SEPA MITIGATED DETERMINATION OF NONSIGNIFICANCE

- Project:** B&J Preliminary Plat (LP-08-21)
- Description:** Application for a 7-lot subdivision of approximately 21.57 acres of land zoned Ag-3 pursuant to Kittitas County Code 16.32.
- Proponent:** Cruse & Associates
Chris Cruse
PO Box 959
Ellensburg, WA 98926
Landowner: Craig and Reesa Duncan
- Location:** The subject property is located west of the City of Ellensburg, north of Manastash Road, east of Cove Road, Ellensburg, WA 98926, and is located in a portion of Section 07, T17N, R18E, WM, in Kittitas County. Specific map number 17-18-07030-0018.

B & J PLAT

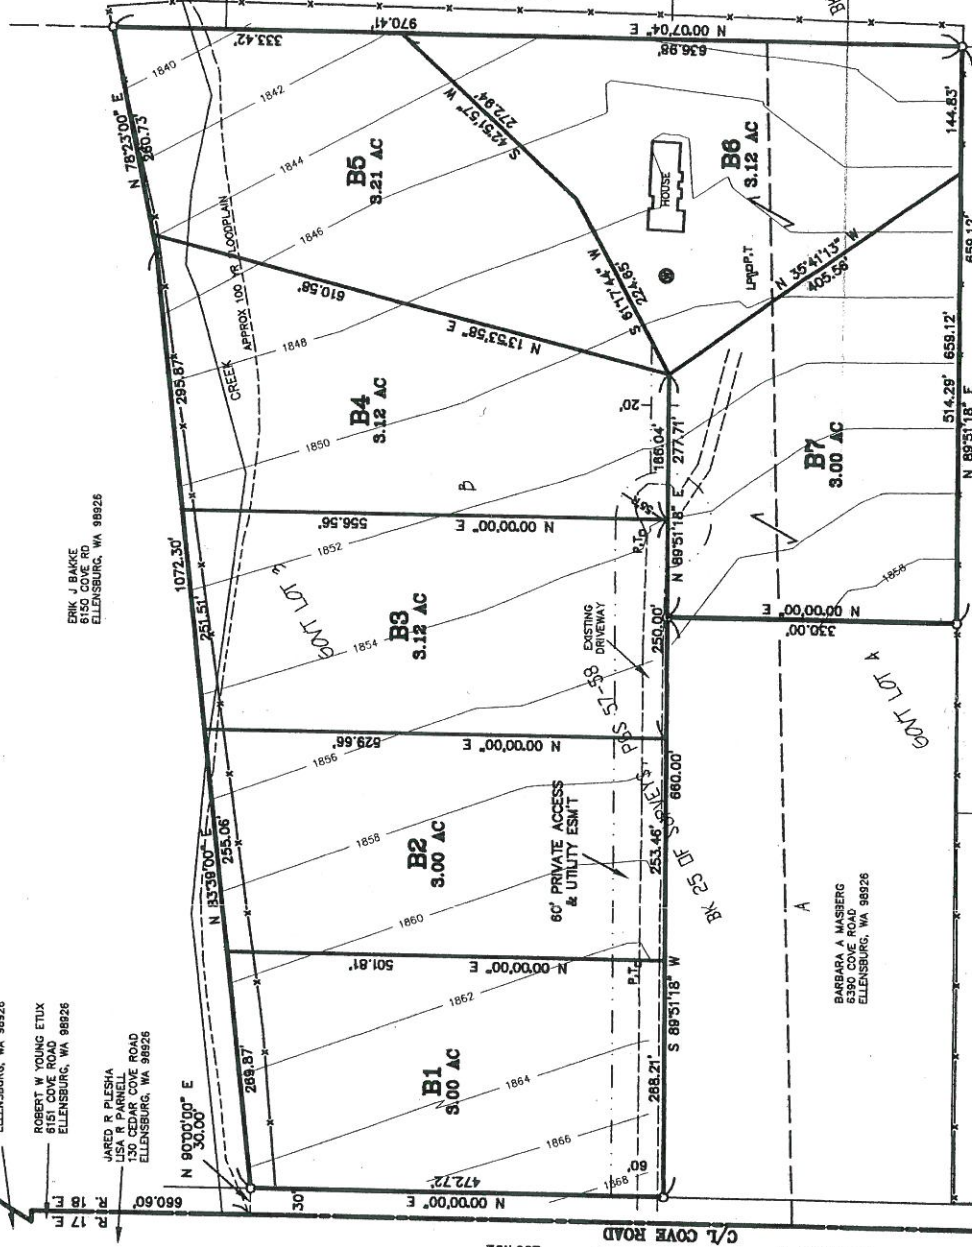
- E. The applicant shall require that shared wells be used to serve this project. Lot B1 and B2 shall share a well, lot B3 and B4 shall share a well, lot B5 and B6 shall share a well, and Lot B7 shall have an individual well. Lots B1 through B7 are part of a single project, the B&J Preliminary Plat (LP-08-21), and the entire project is limited to a single daily groundwater exemption. Each connection shall be allowed 714 gallons per day.

- A. A portion of the subject property is located within the shoreline jurisdiction of Manastash Creek, a Shoreline of the State. No work shall be done (including clearing and grading) and no structures shall be placed within 100 feet of the Ordinary High Water Mark (OHWM) of the creek. The 100 foot buffer shall be delineated and shown on the face of the final mylars.

- C. The 200 foot shoreline jurisdiction, 100 foot buffer area, and associated floodplain of Manastash Creek shall be delineated and depicted on the face of the final mylars.

- D. All development shall comply with the Kittitas County Shoreline Master Program.
- E. All waterways/waters/ditches located on the subject property, regardless of their designation of intermittent, perennial, or ephemeral shall be delineated and depicted on the final mylars. Improvements to such water features shall not impact on-site and off-site use. No diversions (i.e. culverts) or interruptions to any course of water on the subject property shall be incorporated without the approval of the Department of Fish & Wildlife, Community Development Services and the Department of Ecology.

- A. Addresses of all new residences shall be clearly visible from both directions at the county road.
- B. The applicant shall consult with the local school district to determine the safest location for a school bus stop and said location shall be depicted on the final mylars.
- C. The fire department access road shall be capable of supporting 75,000 lbs in all weather, be 20' wide, provide 13'6" vertical clearance and provide for adequate turn-around for fire department apparatus in accordance with IFC 1006-Appendix D.
